Application No: FG/34/21/HH
Site Address: 50 Ocean Drive Ferring BN12 5QP
Description of works: 1st floor side extensions, two storey front extension, side and rear extensions, installation of balcony to rear and 2 x front dormers including demolition of existing garage.

Thank you for your internet representation made on 9th April 2021 which has been recorded as an objection with the comments as follows:

GROUND FLOOR PLAN 1:100 @ A3

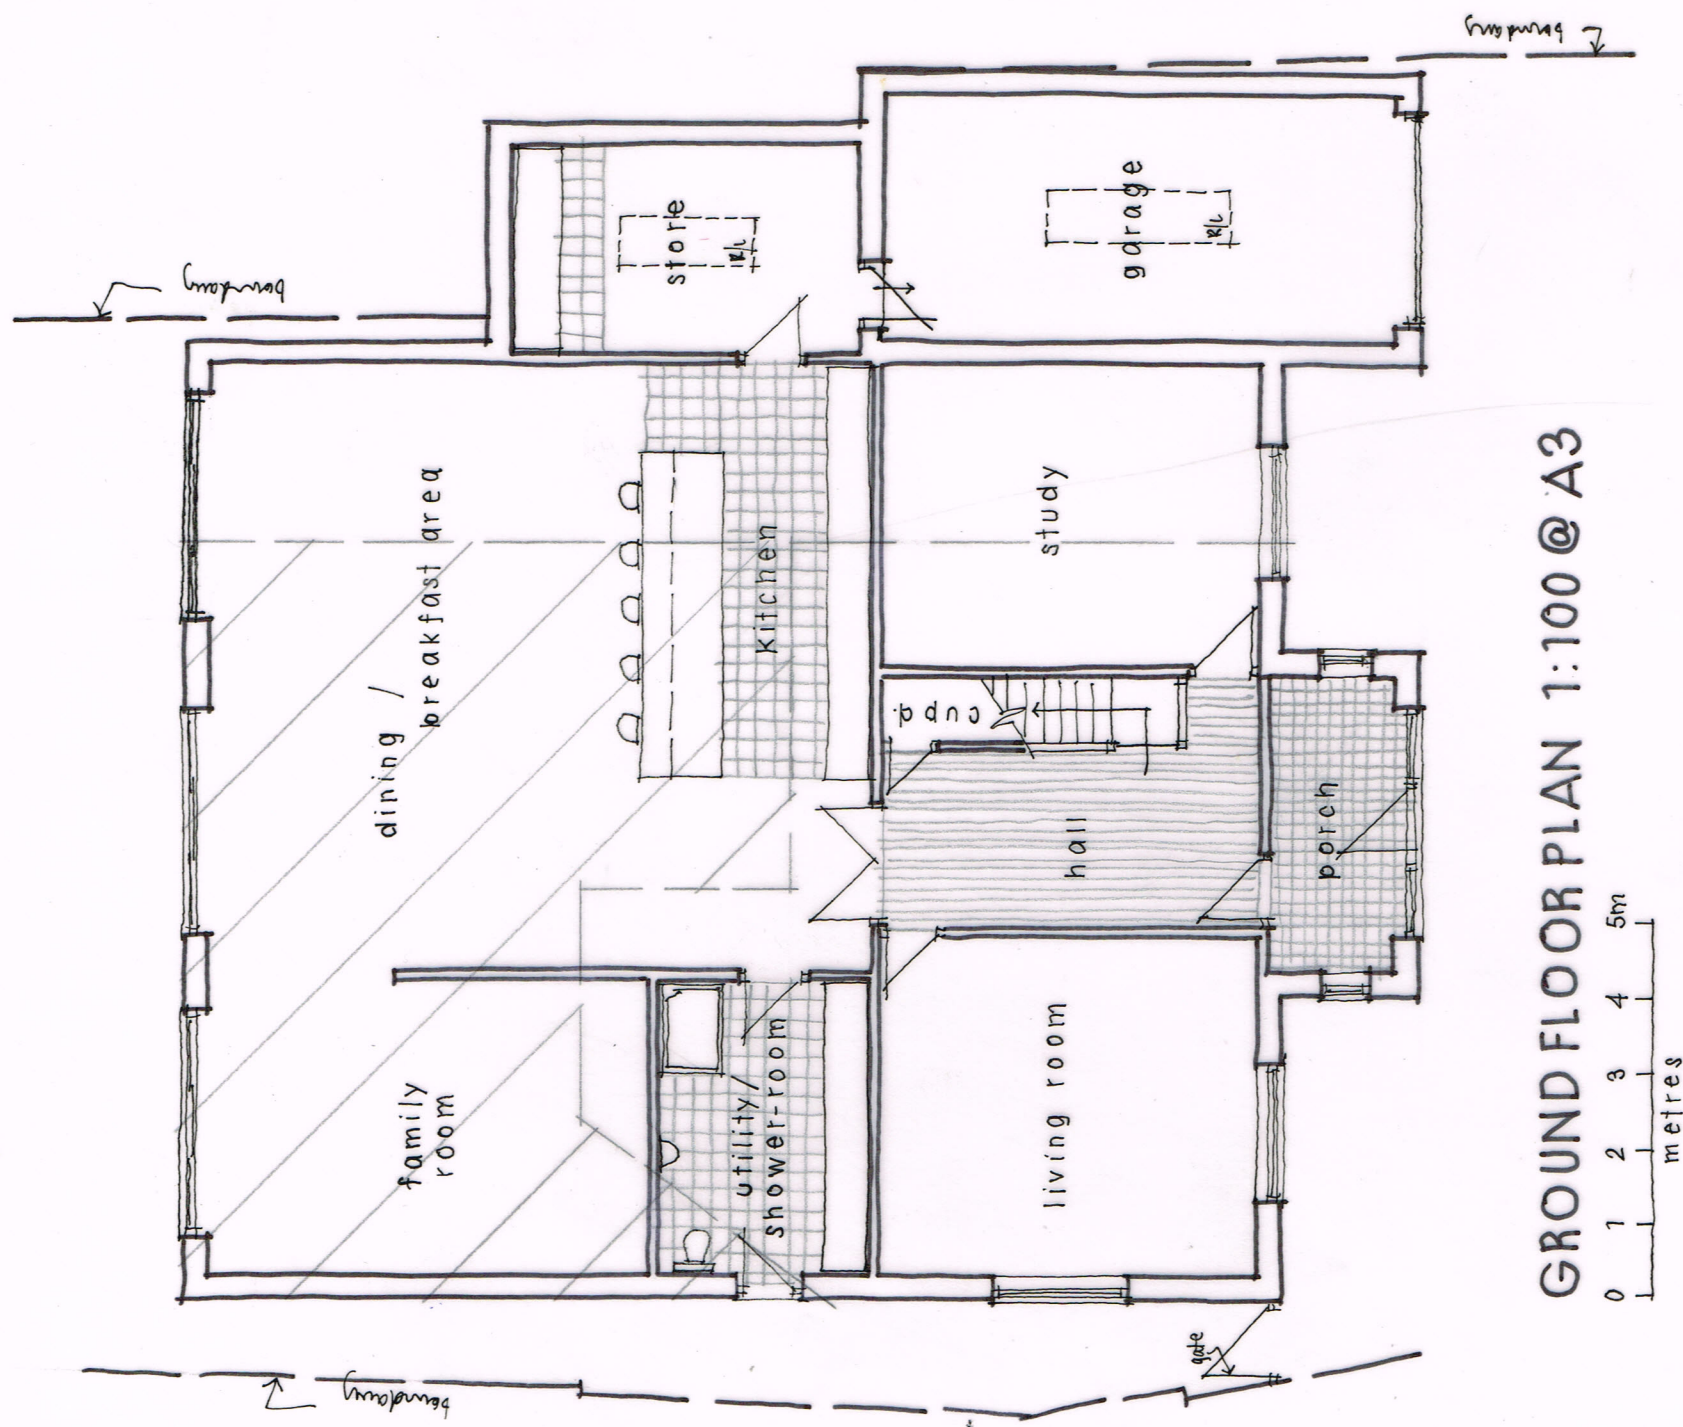
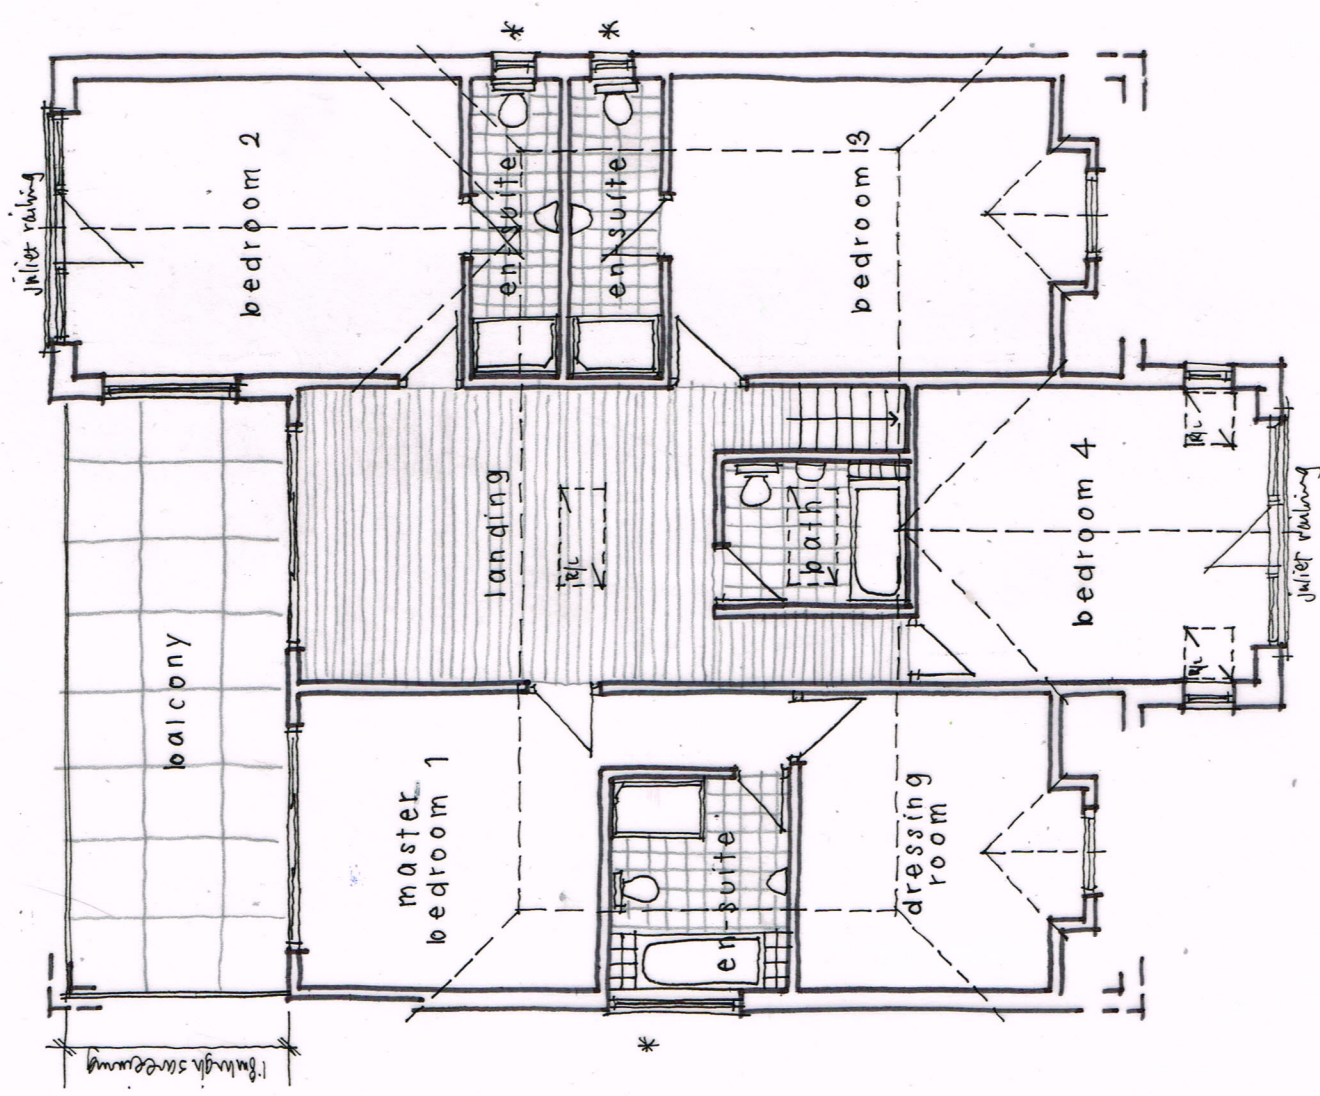
- the size/placement of the new building boundaries are unclear in relation to the existing building
 - There is no indication of how much closer the building will be to our shared boundary and this looks like a deliberate omission/is misleading with regards to assessing the impact of these works on our property

- There are more details of other existing and proposed buildings in the application than the applicant's own proposals
 - The proposed building appears to be about 13m (43ft) wide by 17m (56ft) deep. This gives a ground floor area of almost 2500 square feet excluding the garage

REAR (w)

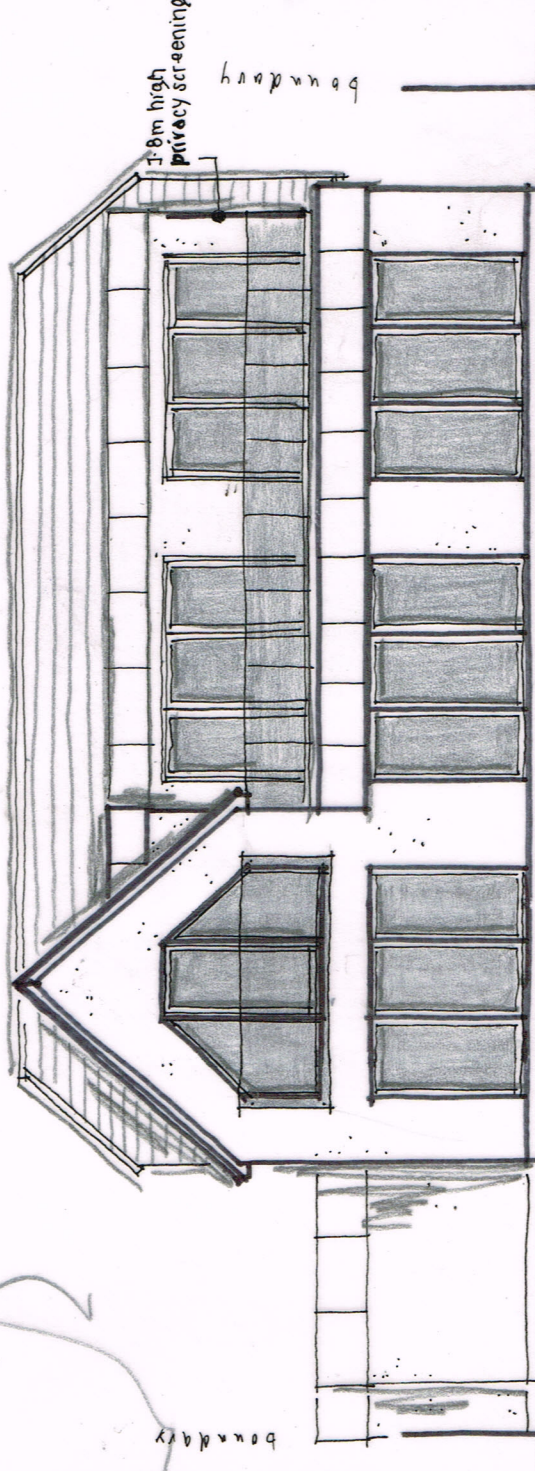
- The proposed design is also not in keeping with the bungalows and chalets that dominate South Ferring
- Of particular concern to us is the full length 1st floor windows & balcony at the rear of the property. It is virtually a wall of windows. The applicant has detailed several properties listed as precedents for various

aspects of the proposal. None of these properties have full length 1st floor windows or a balcony backing onto/overlooking another property. In fact, there is no example of these features anywhere. The applicant tries to justify the balcony as a means to enjoy the afternoon/evening sun which can be achieved by using the extensive existing patio in the rear garden. The wall of windows/balcony will deprive us of the privacy in our garden & allows the applicant views directly into our bedrooms and lounge. Noticing someone's head looking out of a 1st floor window when they are passing by is more acceptable and completely different to someone looking out of a 1st floor full length window or someone leaning over a balcony or sitting at a table for extensive periods eating and drinking and looking in your direction. It is completely unacceptable. Even the thought of this project being approved is having a deleterious effect on ours and our neighbours' mental well-being, some of whom are too old or ill to respond to this application and I would like to be heard on their behalf.
